From: Martyn White <Martyn.White@arun.gov.uk>
Sent: 11 March 2022 17:00
To: Planning.Responses <Planning.Responses@arun.gov.uk>
Subject: LU/382/21/PL

LU/382/21/PL

71 High Street Littlehampton BN17 5AE

Refurbish and renew the first and second floors of the existing building to the southern side of the site, with a new build proposal to the northern half of the site, creating a new entrance and entrance stairwell with bicycle and bin storage to the existing ground floor area and a new two storey (1st and 2nd floor) build co-living, 23 bed HMO scheme above together with the change of the use to the former bank (Use Class E) to four commercial units (Use Class E). This application may affect the setting of a listed building.

DRAWING TITLE :
PROPOSED ELEVATIONS & SECTIONS

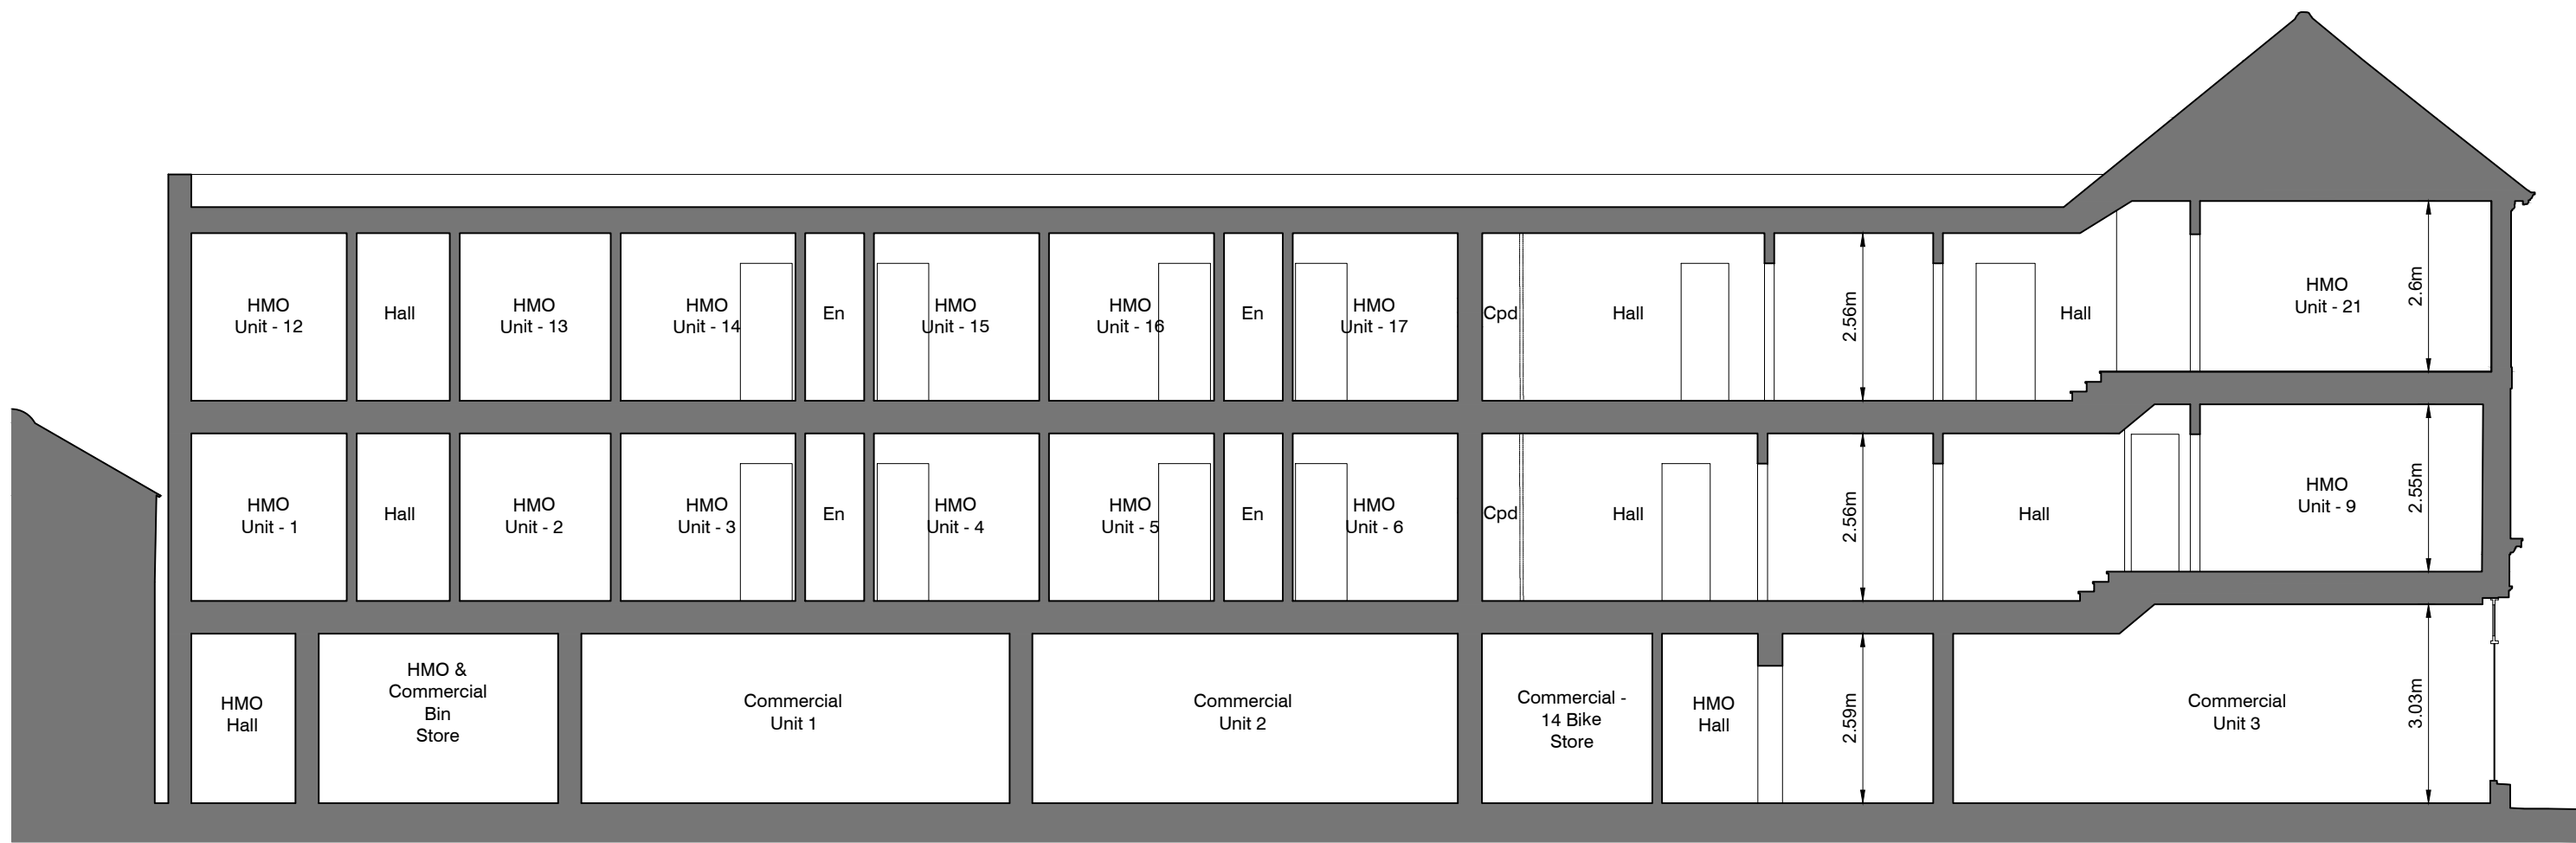
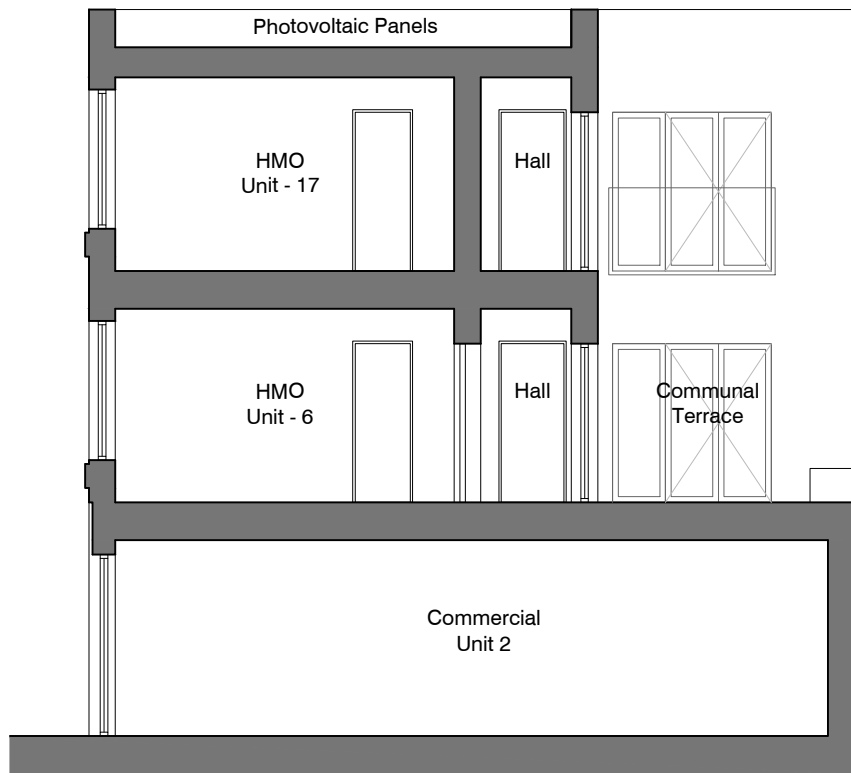
The proposed development will form a three storey extension which will accommodate the majority of the site (the remainder is already three storeys). The height and form of the building structure will appear incongruous, overlarge, and distinctly out of keeping with the two storey, pitched roof form of the buildings opposite and to the north of the application site. Unlike both the host building and most of those in the local area, the extension will have a large flat roof which will clearly be seen from the local streets be out of character. I am of the opinion that the nearby building on Church Street should not set a precedent for allowing a prominent roof in this location – this building is itself out of character with those buildings around it. The elevation of the extension is also not reflective of the host building and reads more as though it has been designed based on a standard list of parts.

The extension would also lead to the loss of the existing separation between the host building and the building identified as number 2 and 4 East Street, and the formation of continuous new development. This would also lead to the loss of the visual prominence of the existing host building along with the interesting detailing.

It is noted that the proposed windows will be UPVC in a design and method of operation that is conflict with the existing windows (which appear as vertically sliding timber sash windows). I should also point out that the loss of the existing windows which make a positive impact upon the building and local area is harmful and would have a negative impact and cannot be supported.
